# Markup Summary

SHEET INDEX		
1	C2.0	COVER SHEET
2	C2.1	GRADING PLAN
3	C2.2	EROSION CONTROL PLAN
4	C2.3	EROSION CONTROL DETAILS

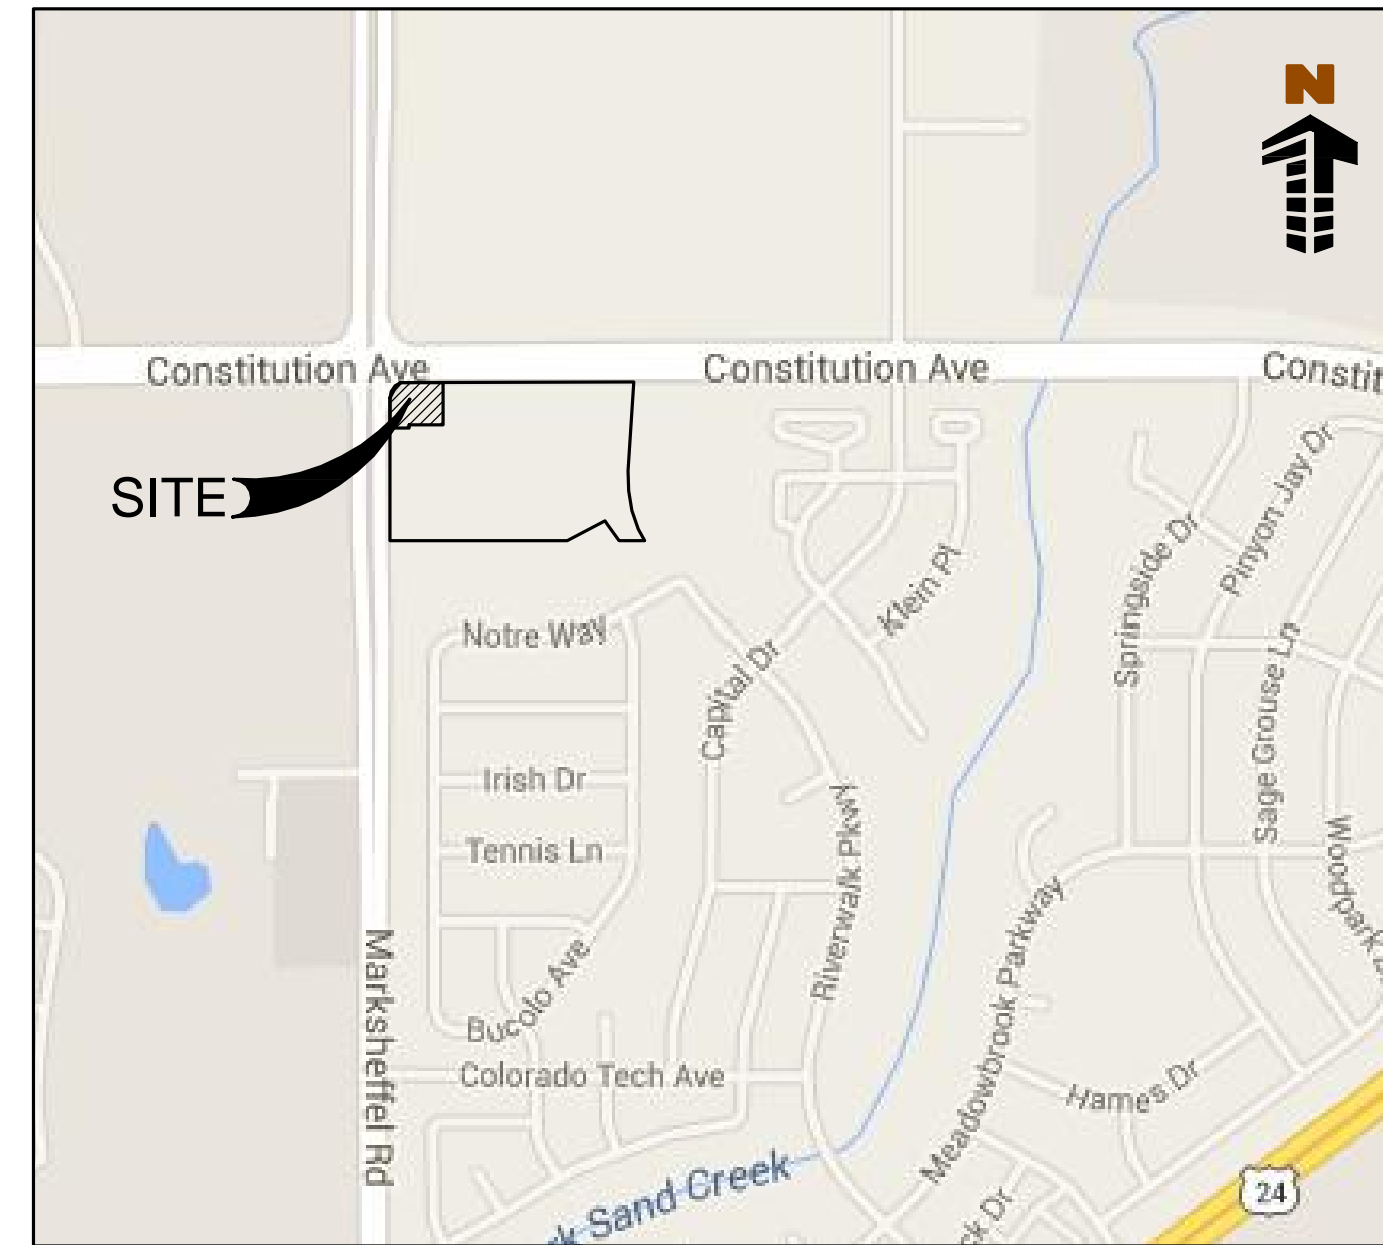
Add "PCD File No. PPR-18-012"

GRADING PLAN  
EPC 7/19/18

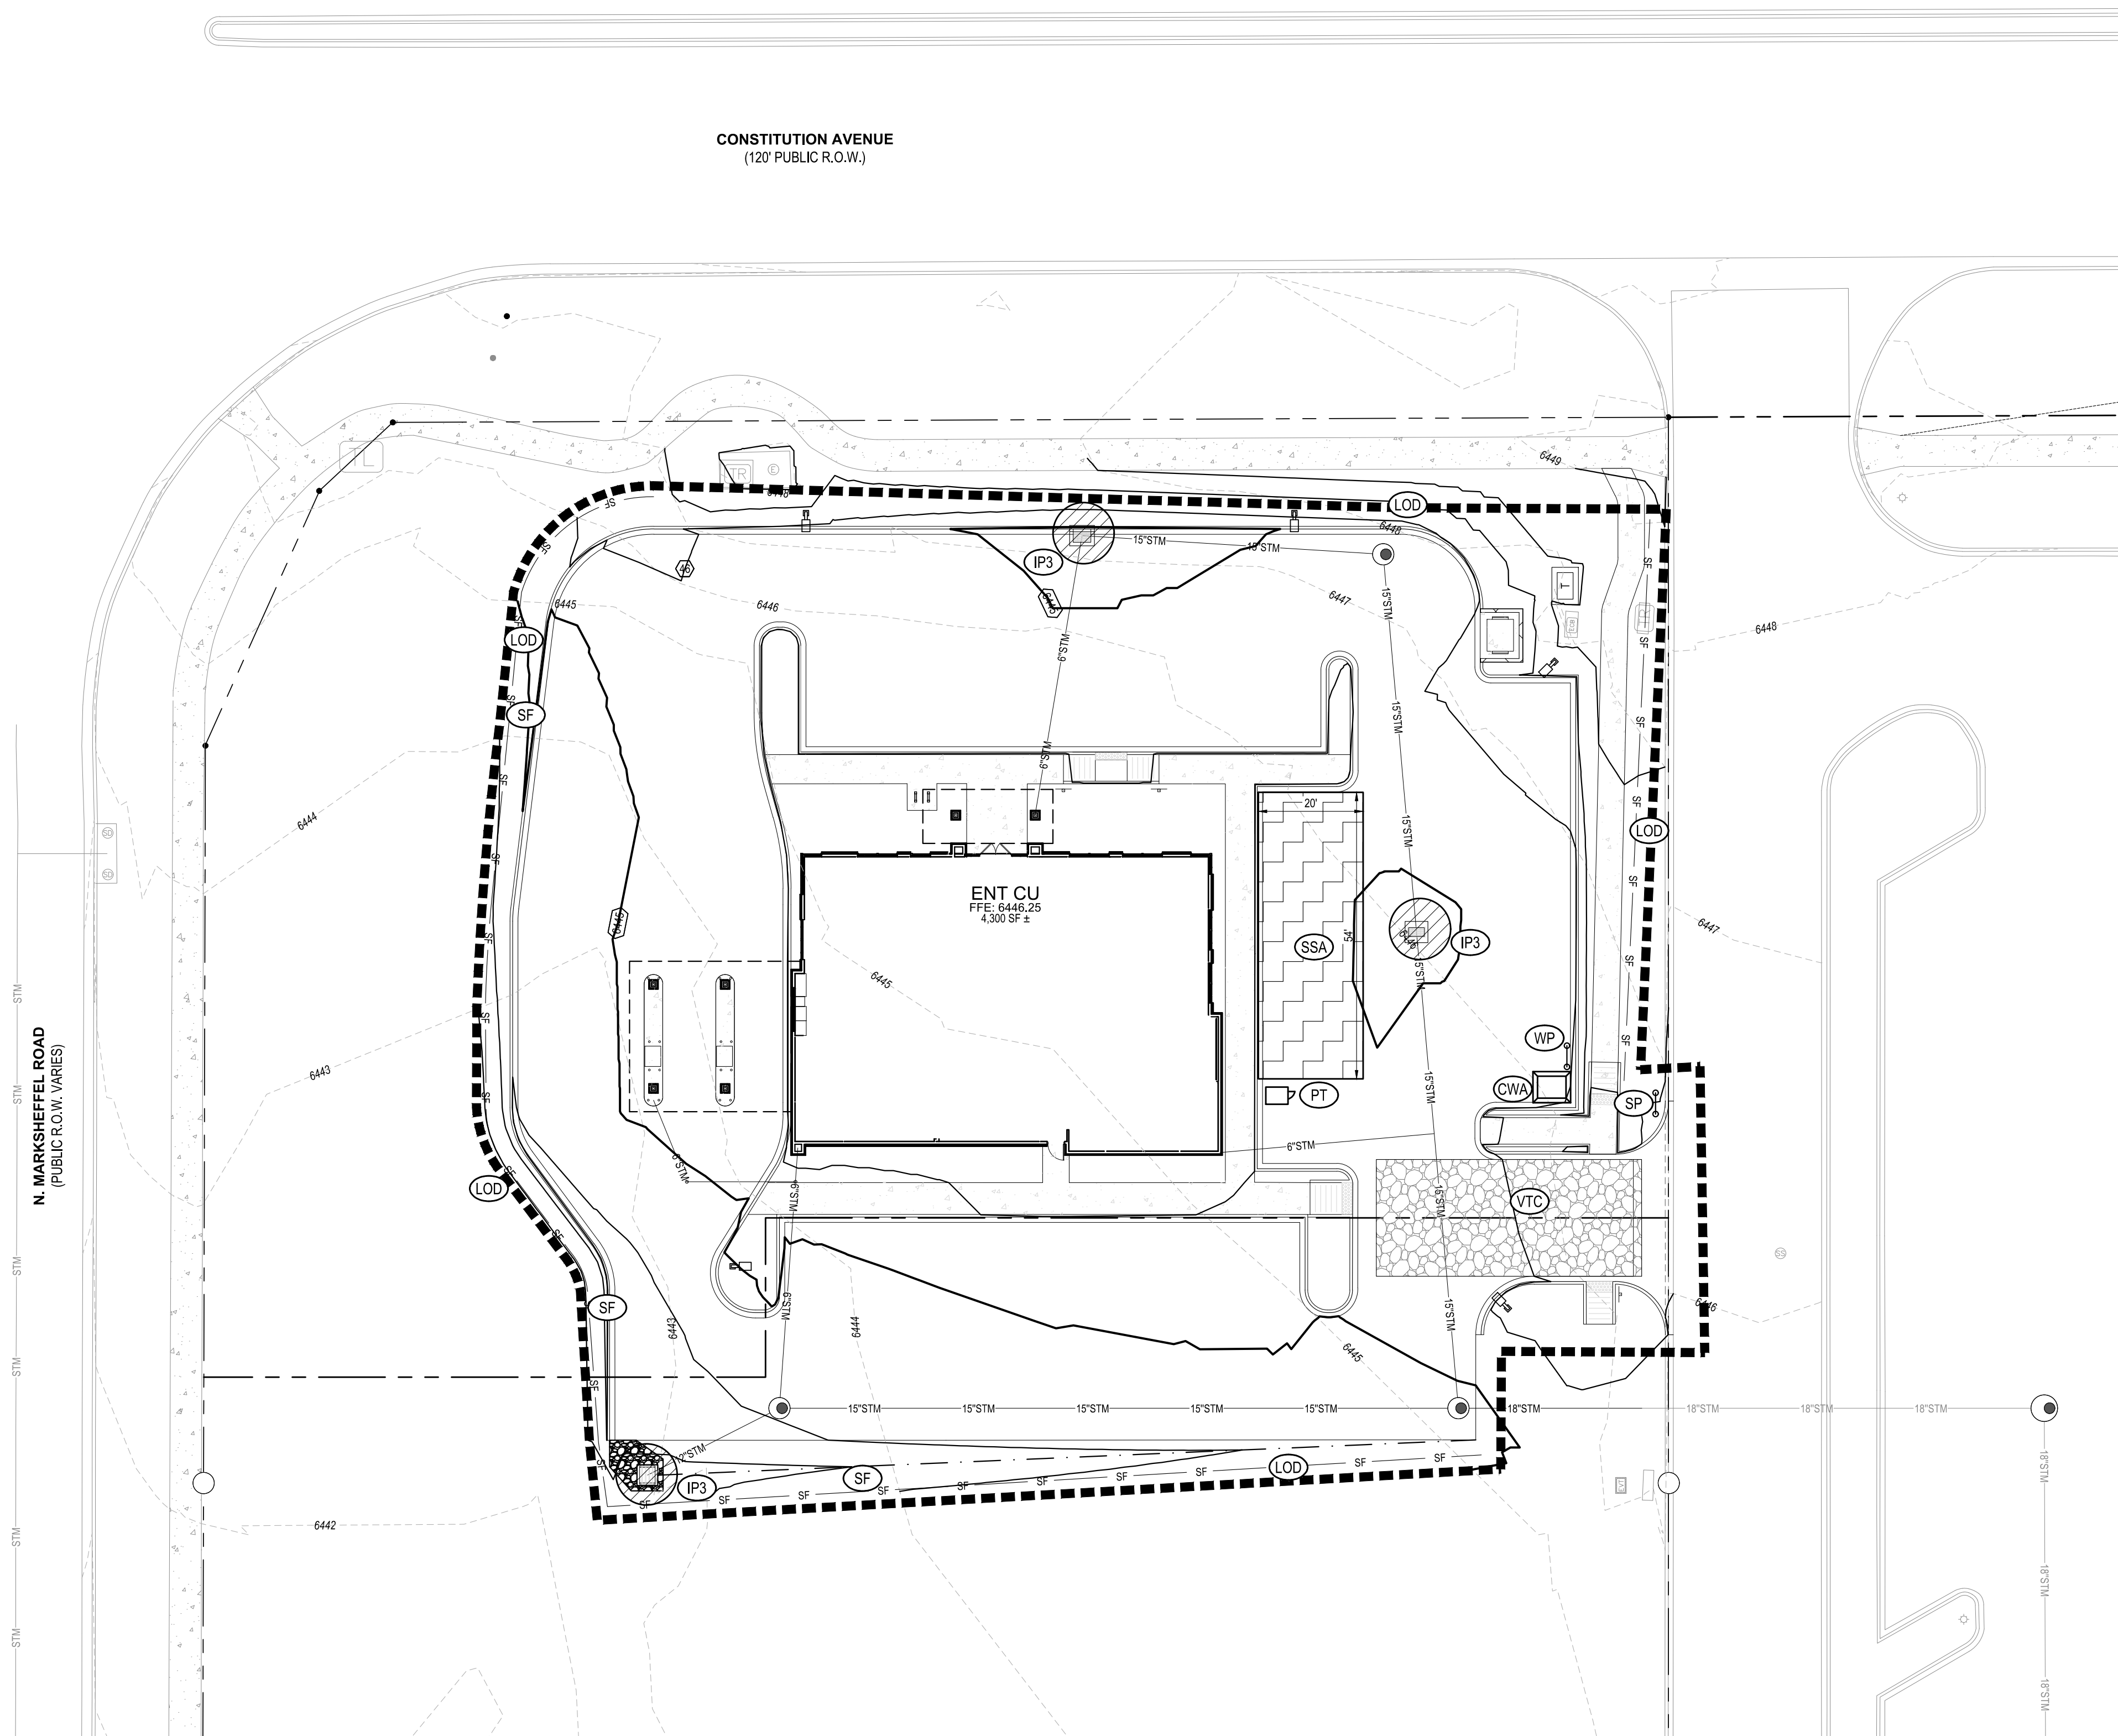
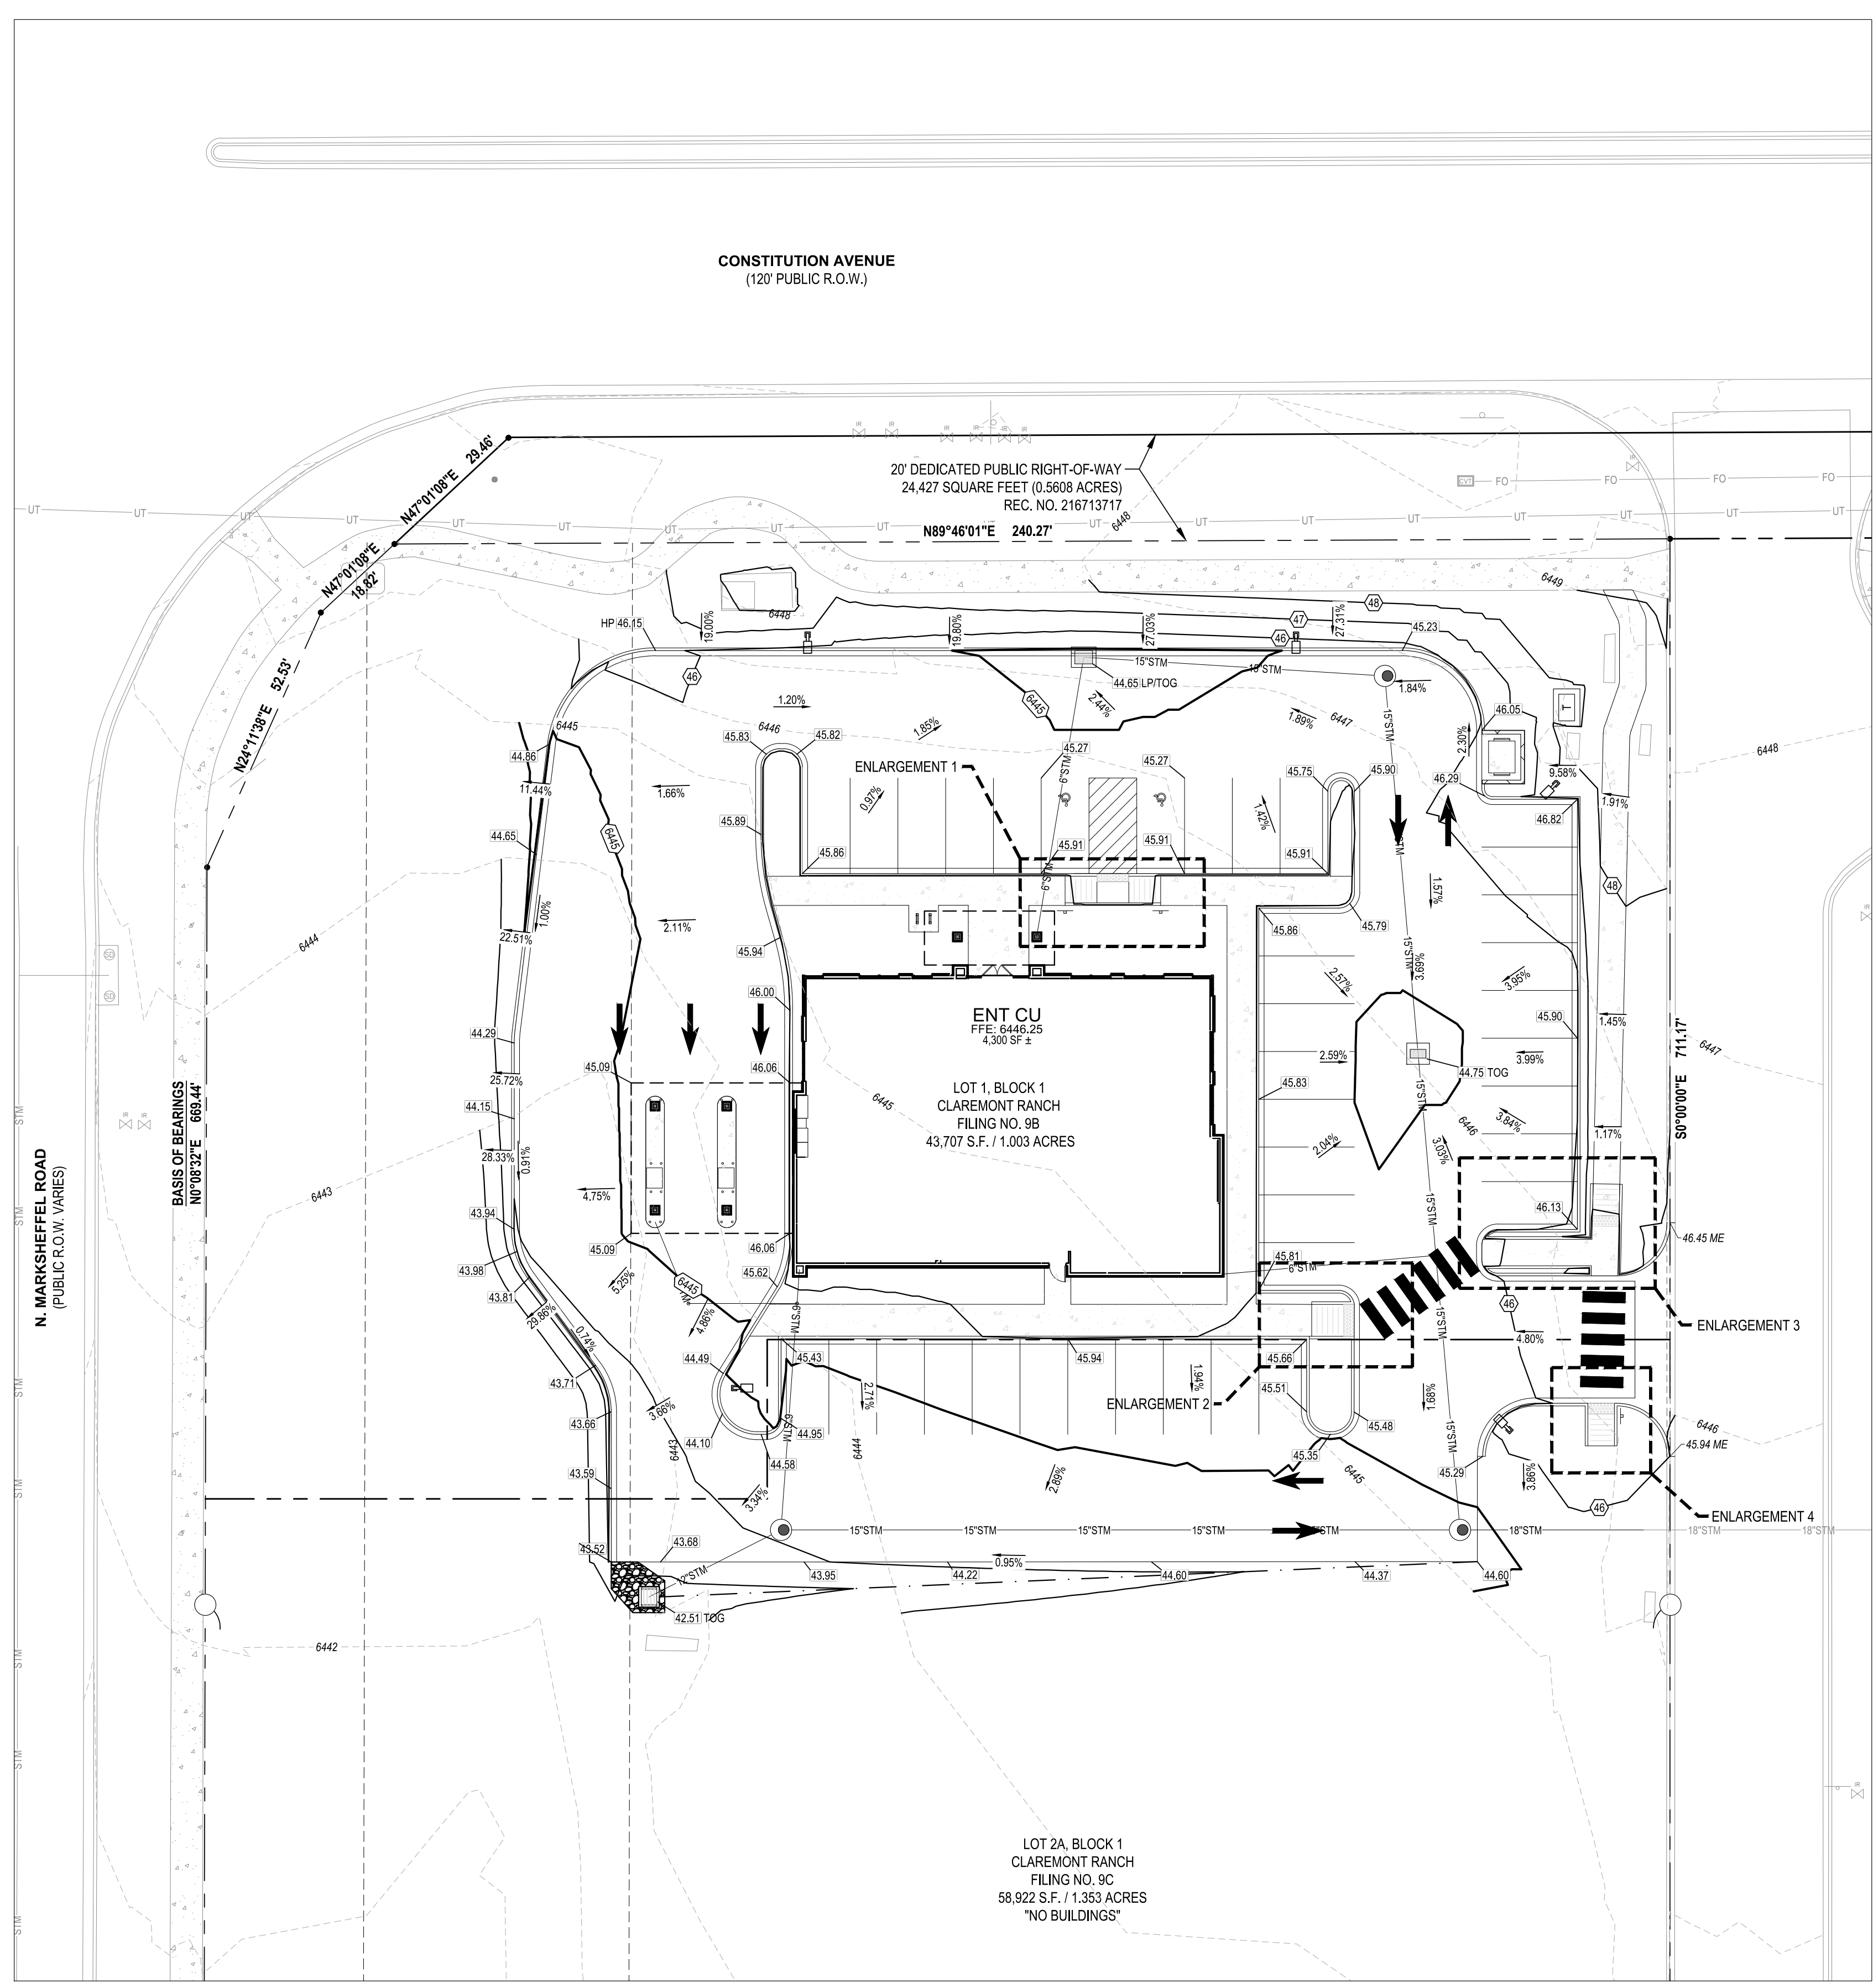
Based on the grading it appears that concentrated runoff from the C&G will bypass the inlet.

Revise cross slope to 2% max per site plan detail

Revise. 12:1 max
